From: dane@tnesinc.com
Sent: Monday, June 18, 2018 2:25 PM
To: jmaynard@nescolorado.com
Cc: Marc Whorton; 'Luanne Ducett'
Subject: Timberridge Estates - Revised Drainage Report
Attachments: 173300 FDR.pdf

**PRELIMINARY/FINAL DRAINAGE REPORT
FOR
TIMBERRIDGE ESTATES, PRELIMINARY PLAN
PART OF THE RETREAT AT TIMBERRIDGE
(NORTH OF ARROYA LANE)**

Job No. 1733.00

SP-18-002

**DESIGN POINTS SURFACE ROUTING SUMMARY - EXISTING CONDITIONS**

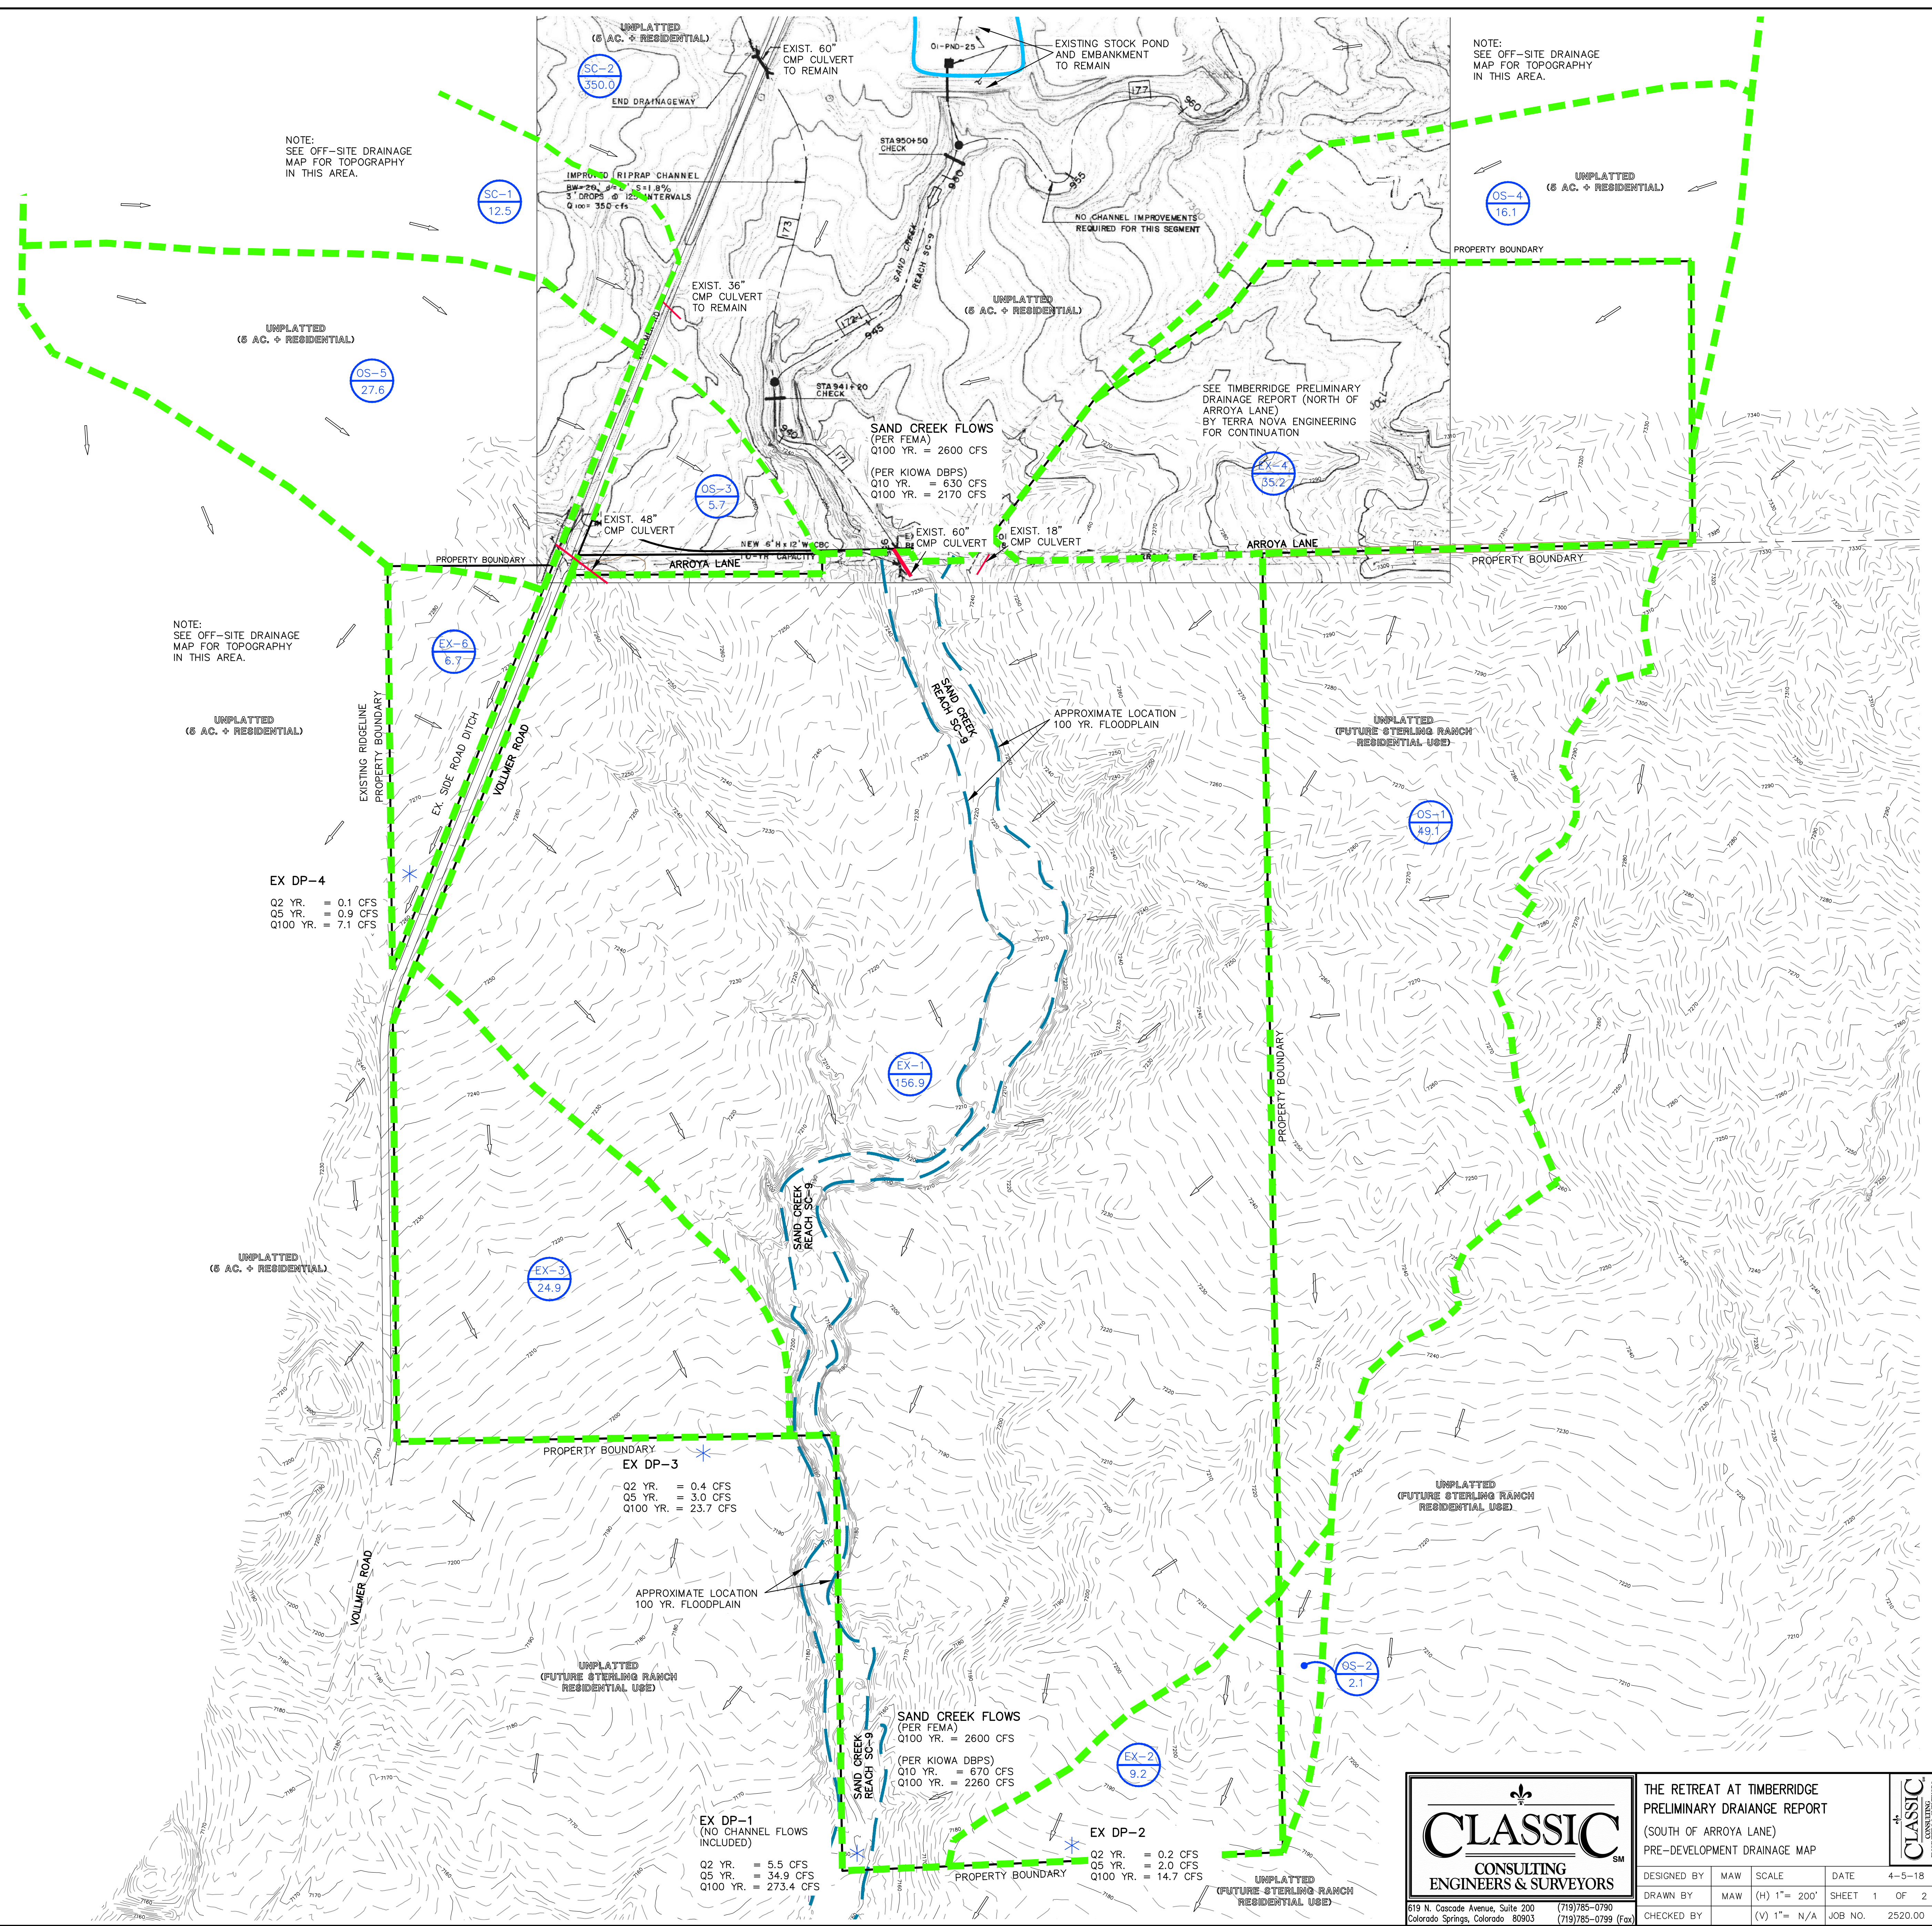
- Page 4, 2nd paragraph – Q: rural residential? X2, A: Yes to both.
- Page 7, 4th paragraph – Q: HOA or district?, A: District.
- Existing Drainage Plan – Q: What is this line?, A: It is the boundary of a surface feature in CAD, which shouldn't have been shown.
